An
Bord
Pleanála

Board Order ABP-313750-22

Application for ten-year planning permission under section 37E of the Planning and Development Act 2000, as amended, in accordance with plans and particulars, including an Environmental Impact Assessment Report and Natura Impact Statement, lodged with An Bord Pleanála on the 7th day of June 2022 by Energia Renewables ROI Ltd care of MKO, Planning and Environmental Consultants, Tuam Road, Galway, Co. Galway as amended by the further information received by An Bord Pleanála on the 10th day of July 2023.

Turbine 12 Layout

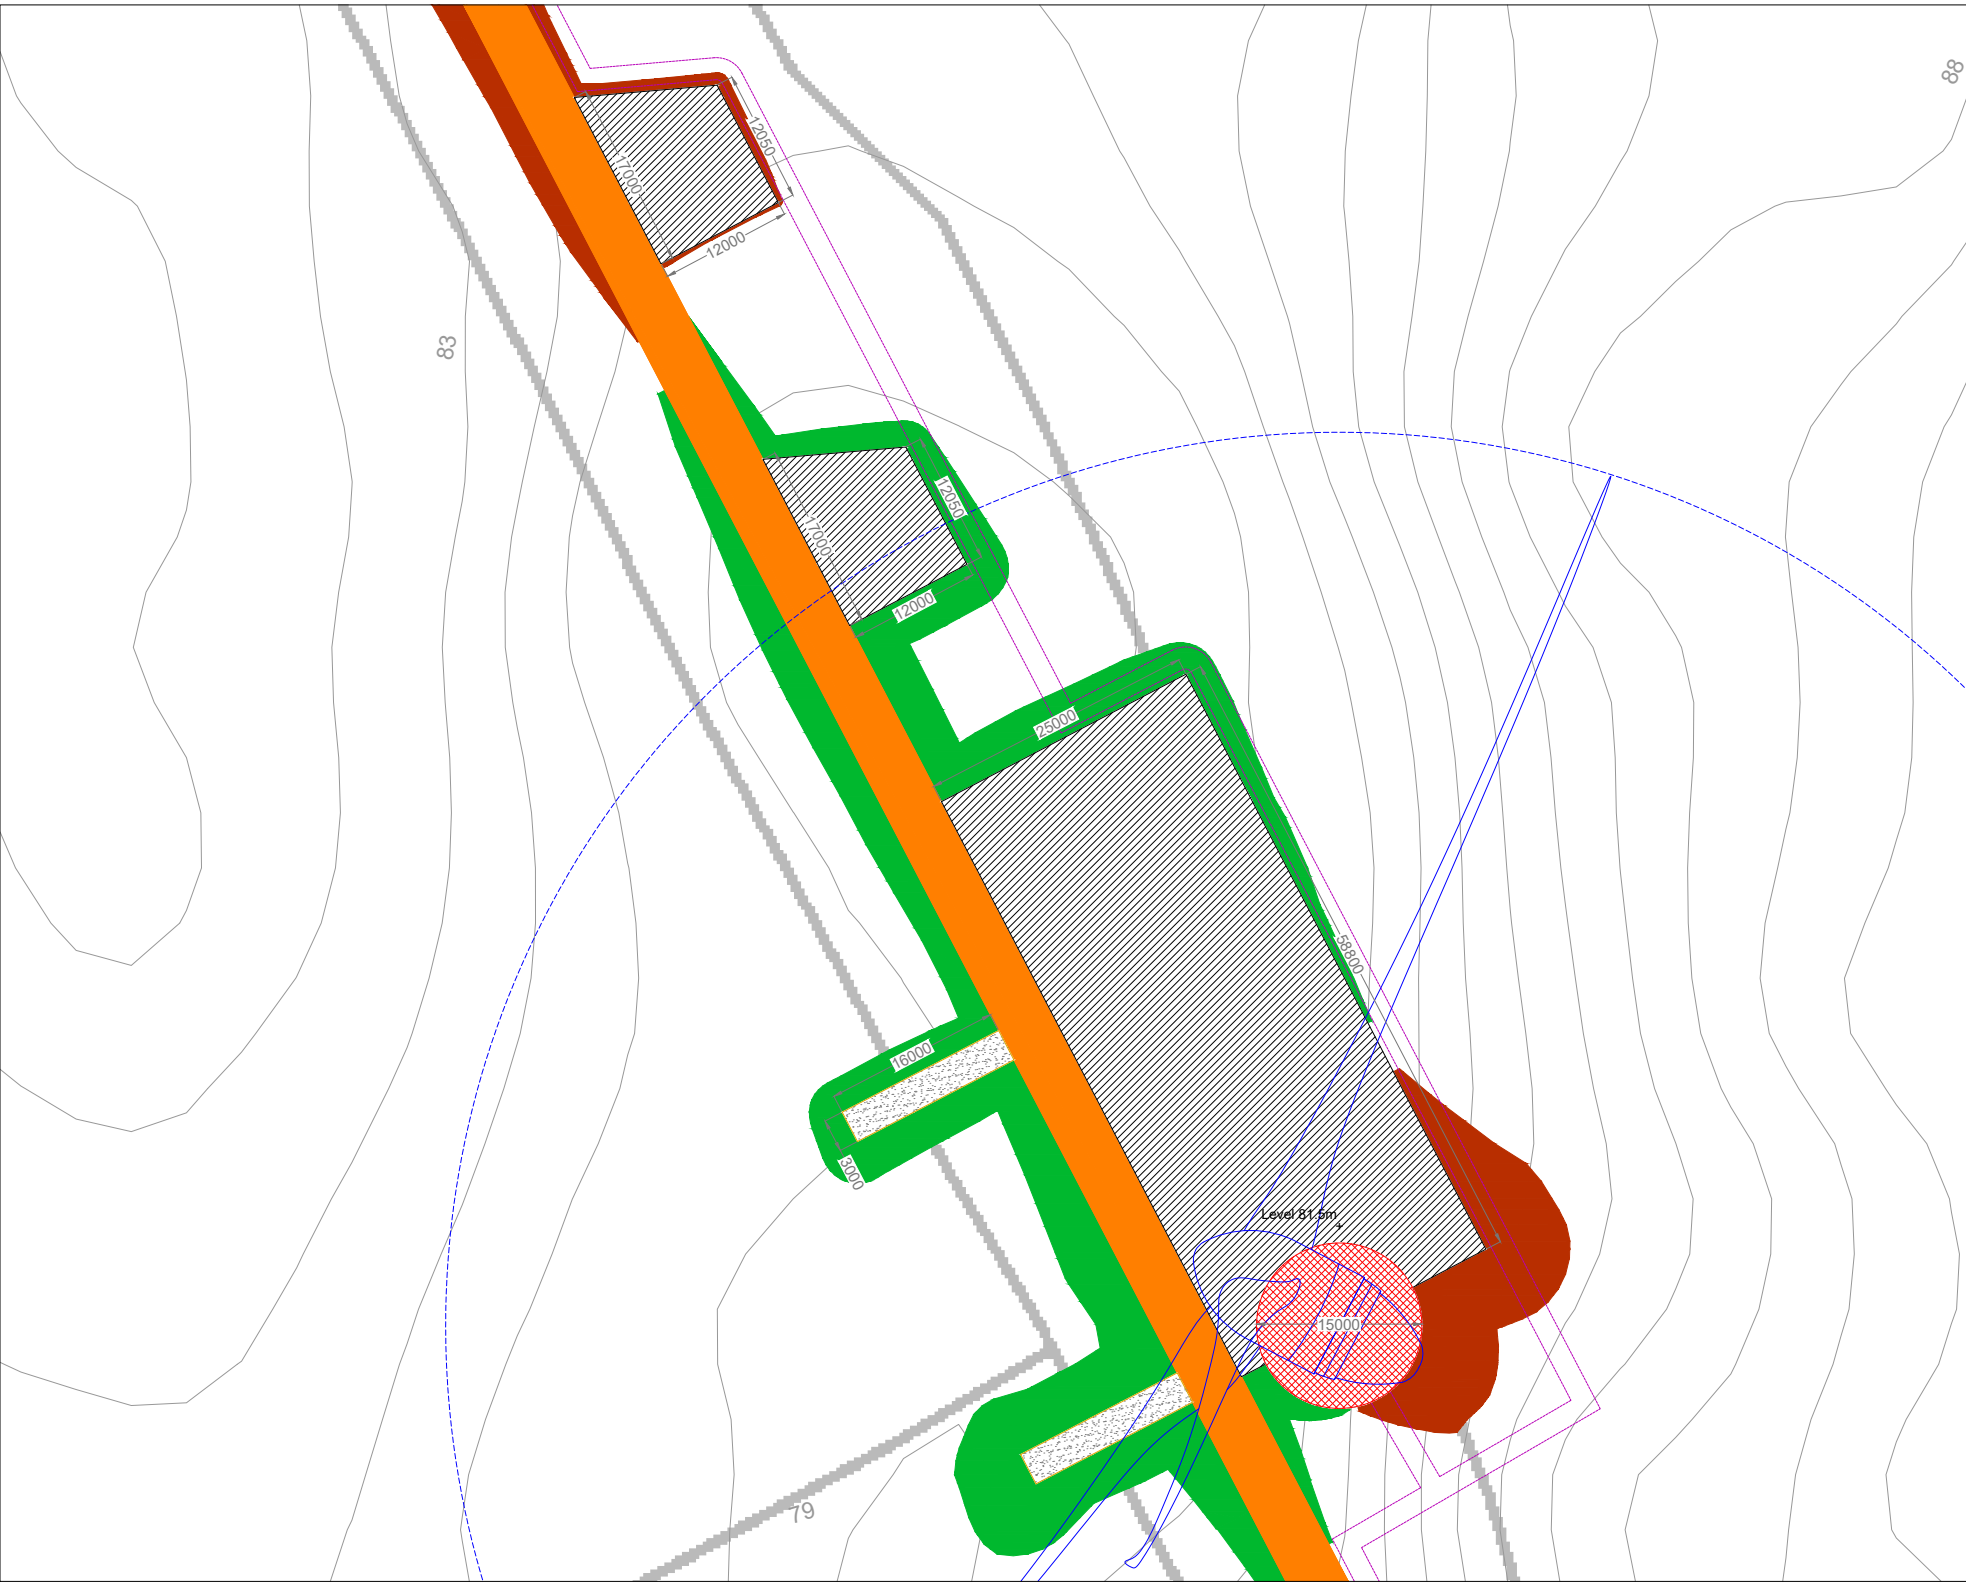
4. The design and layout of the development shall be amended to omit the three wind turbines T9, T10 and T12 which would be located within the Killeglan Karst Landscape in the Southern Turbine Cluster. The Killeglan Karst Landscape is a County Geological Heritage site of National Importance, and Policy NF10.11 of the Roscommon County Development Plan 2022 to 2028 seeks to preserve and protect sites of county geological importance from inappropriate development where they comprise designated sites or national heritage areas.
